Our Ref.:
HC2013/29

Date: 30 October 2013

Re: **Peer Review - Groundwater Impact Assessment, NorthParkes Mine Step Change Project**

Figure C10: Modelled Total Inflow Rates to the Mine

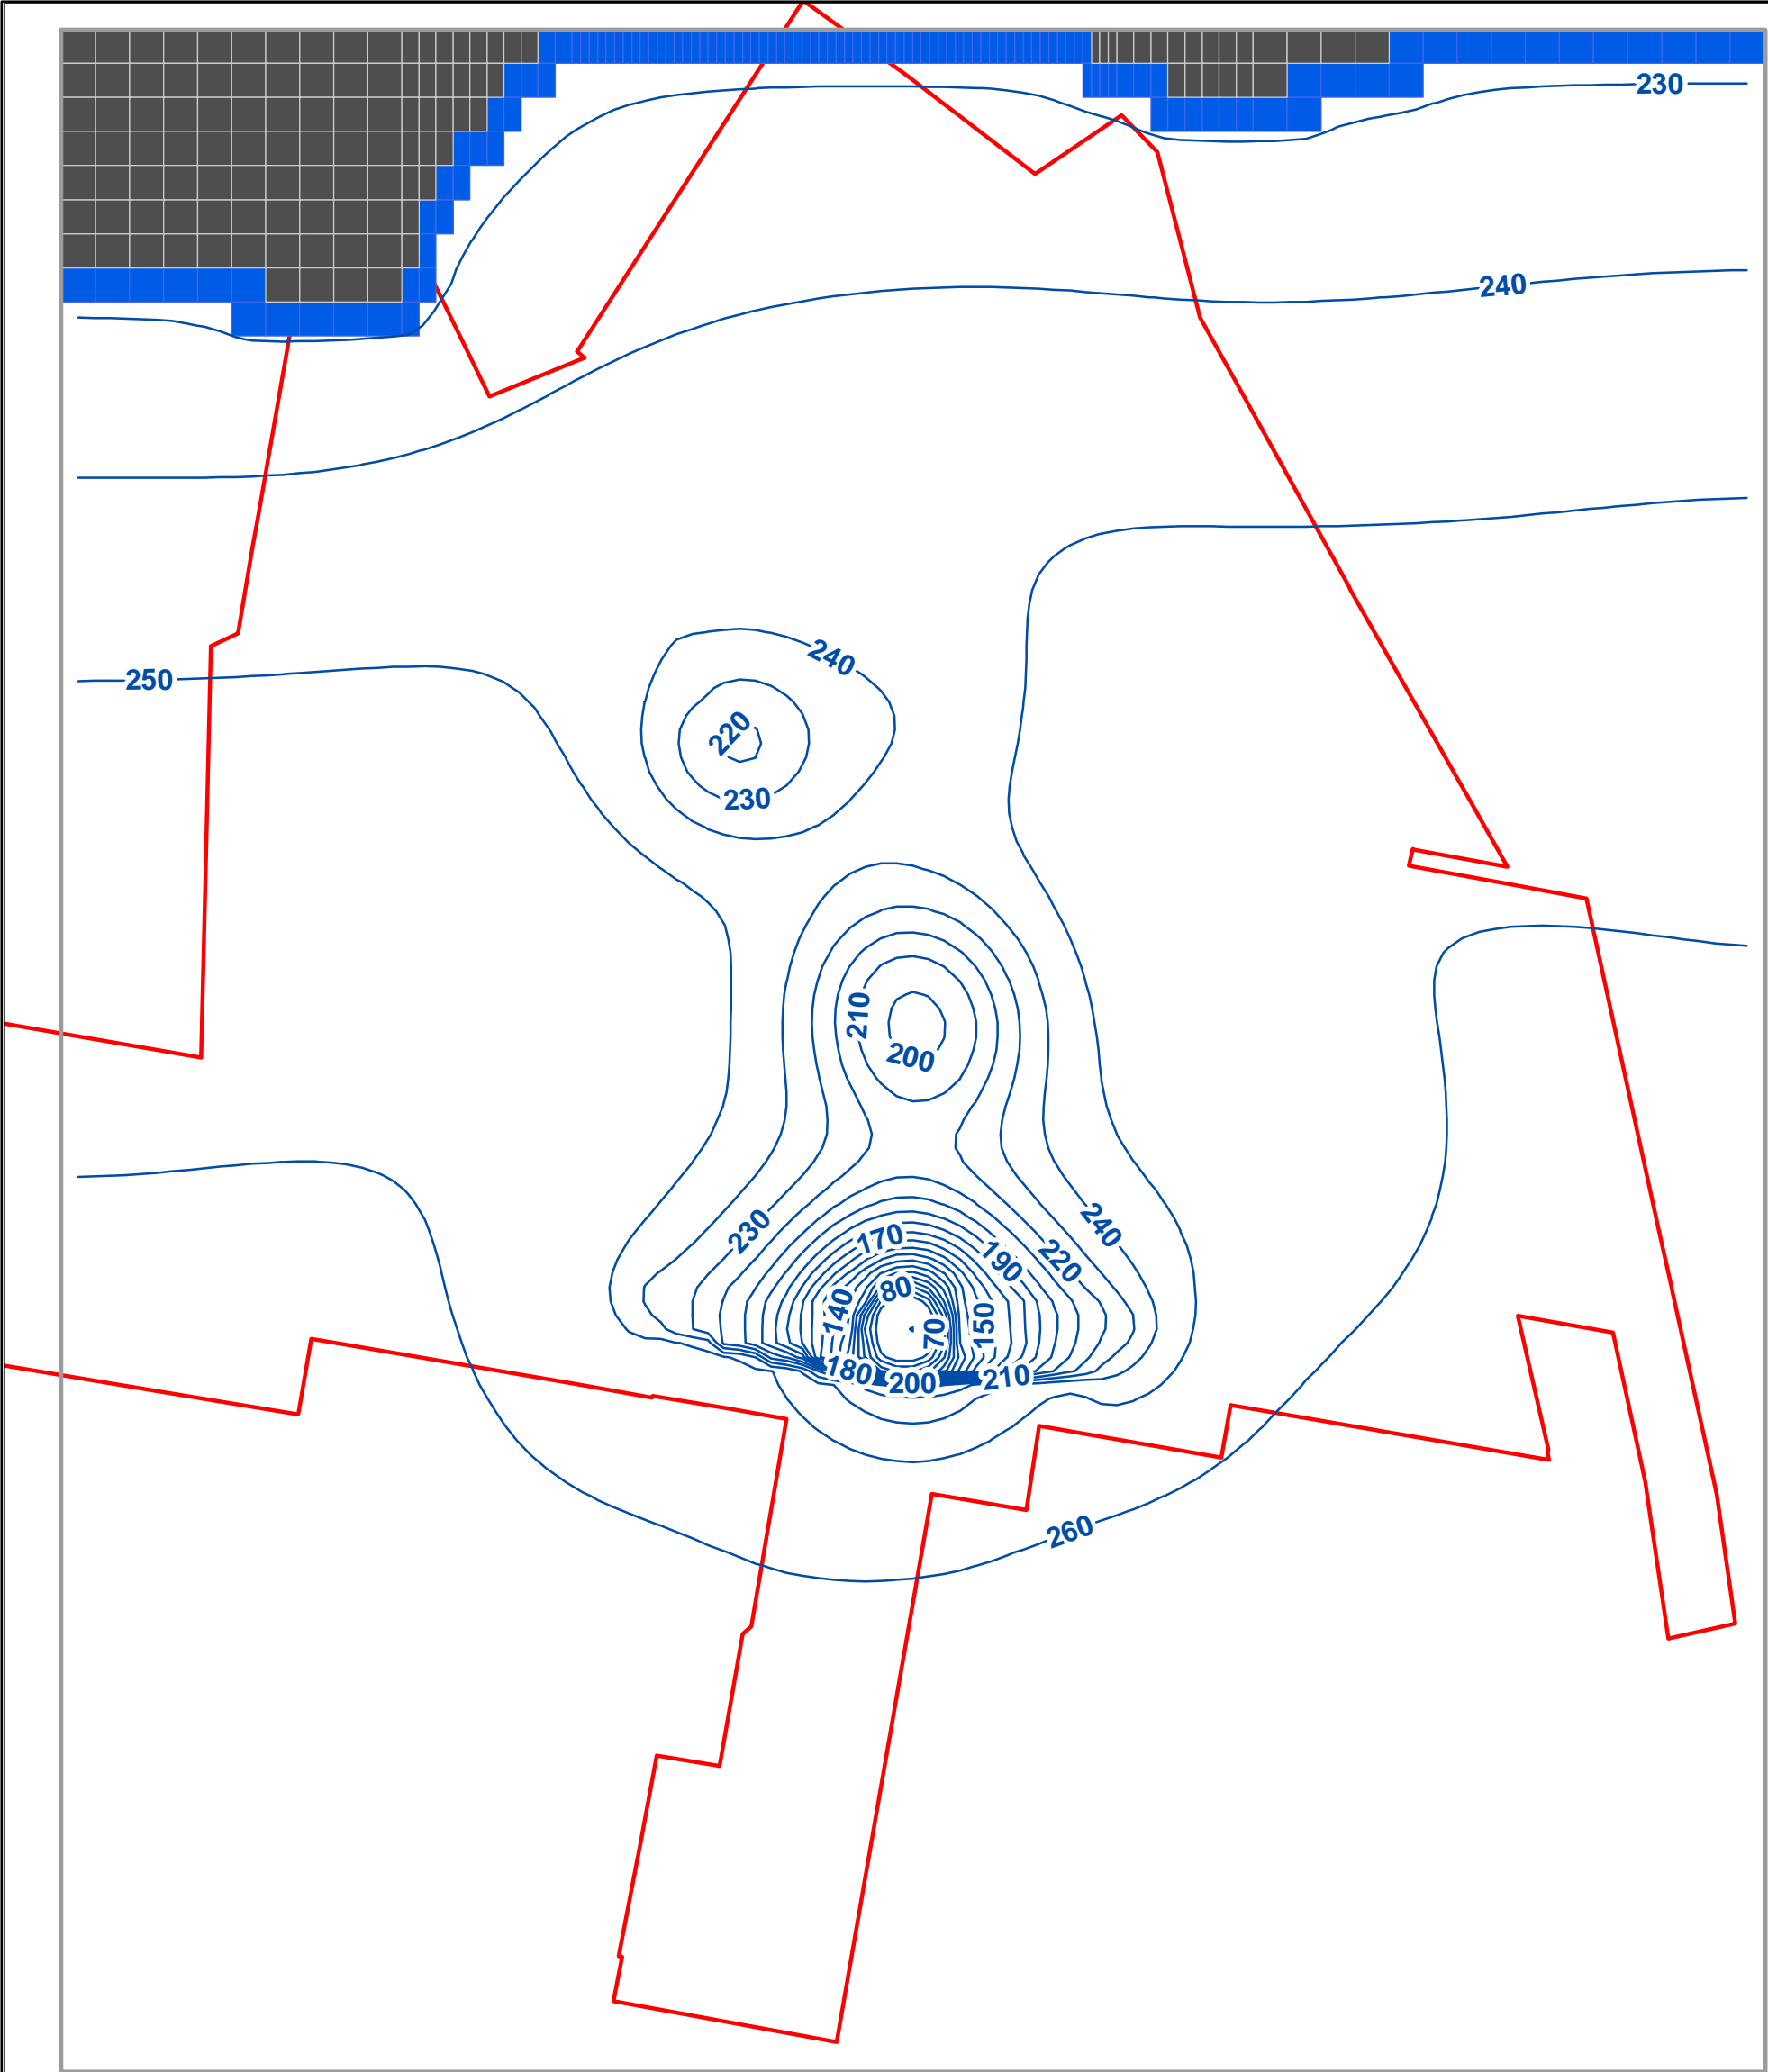
The water balance in Table C9 of Appendix C [Document #1] seems to report mine inflows ("Drain outflow") that are not consistent with the rates shown in Figure C10. The Table has 0.45 ML/day during the calibration period and 0.22 ML/day averaged across the prediction period. The rates should be closer to 0.8 ML/day, as stated in the Executive Summary.
